Recommendation Report for Planning Permission for Works or Extension to a Dwelling

REF NO: BR/199/21/HH

LOCATION: 38 Victoria Drive  
Bognor Regis  
PO21 2TE

PROPOSAL: Erection of 6 foot fence in front garden following the removal of existing hedge and wall and extend existing dropped kerb

splay plan 38 Victoria Drive

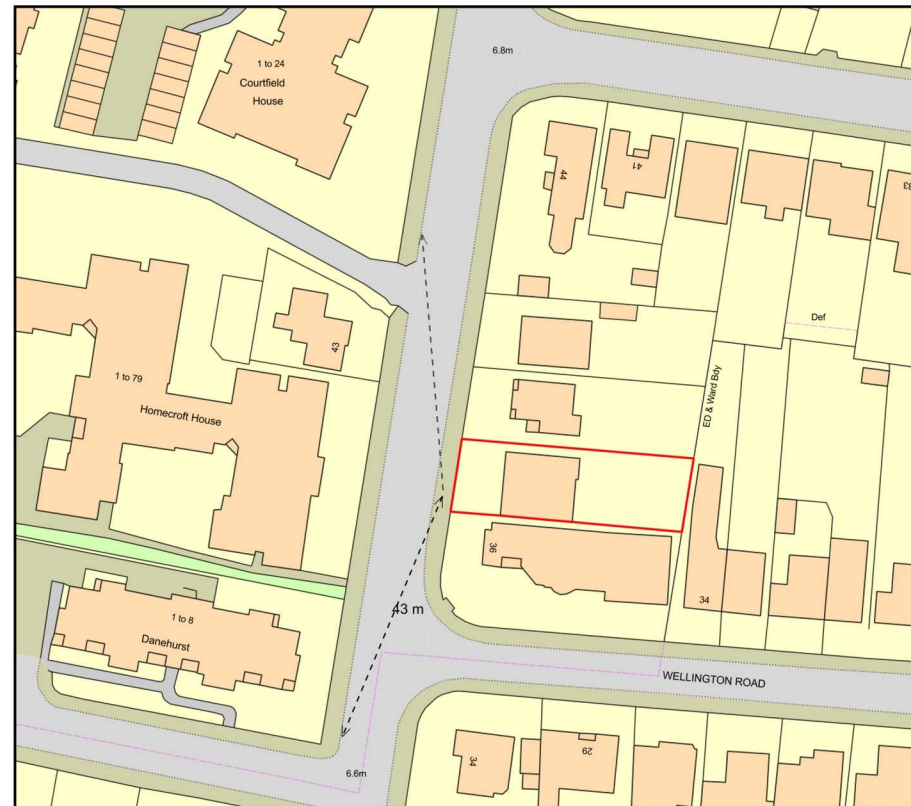
The application seeks to erect a 1.83m high wooden boundary fence to front (west) boundary of property to replace existing hedge and low brick wall.

Due to the siting to front (west) the fence will be highly visible from street scene. Due to the height and scale of fence it is not in-keeping with surrounding properties and out of character within surrounding area so adversely impacts character of area so conflicts with policy D DM1 of the Arun Local Plan.

Whilst neighbouring property number 40 Victoria Drive to north has a wooden boundary fence, it is at a lower height and retains existing hedging. The proposed fencing is at a much greater height and the removal of the existing hedge/wall is out of character within surrounding area so conflicts with policy D DM1 of the Arun Local Plan and the Arun Design Guide.

# Vehicle Crossover/location plan

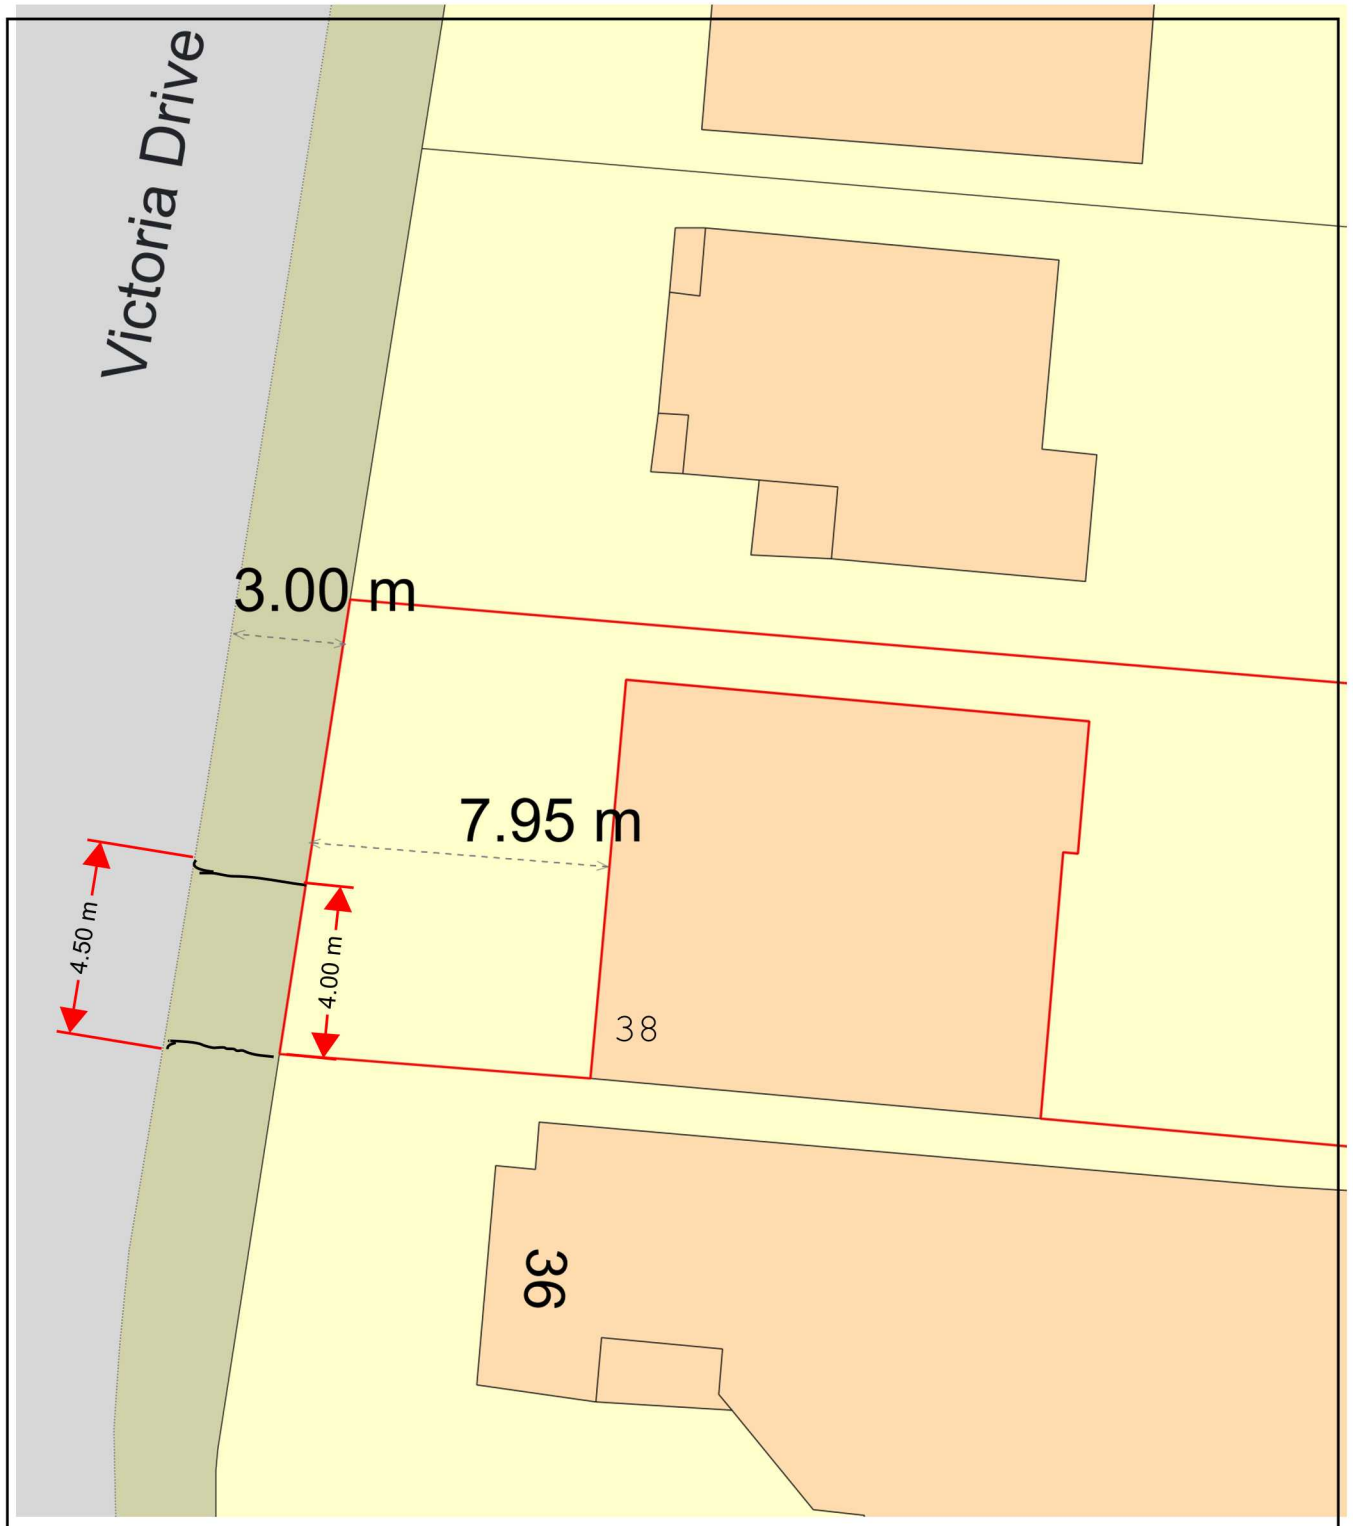
The fence would be 3m away from the highway edge.

There is an existing dropped kerb to front. The proposed extension to dropped kerb is not out of character within surrounding area.

- 1 The proposed new fence to front (west) boundary by reason of its siting, height and scale will have an unacceptable impact on the appearance and character of the surrounding area in conflict with policy D DM1 of the Arun Local Plan and the Arun Design Guide.
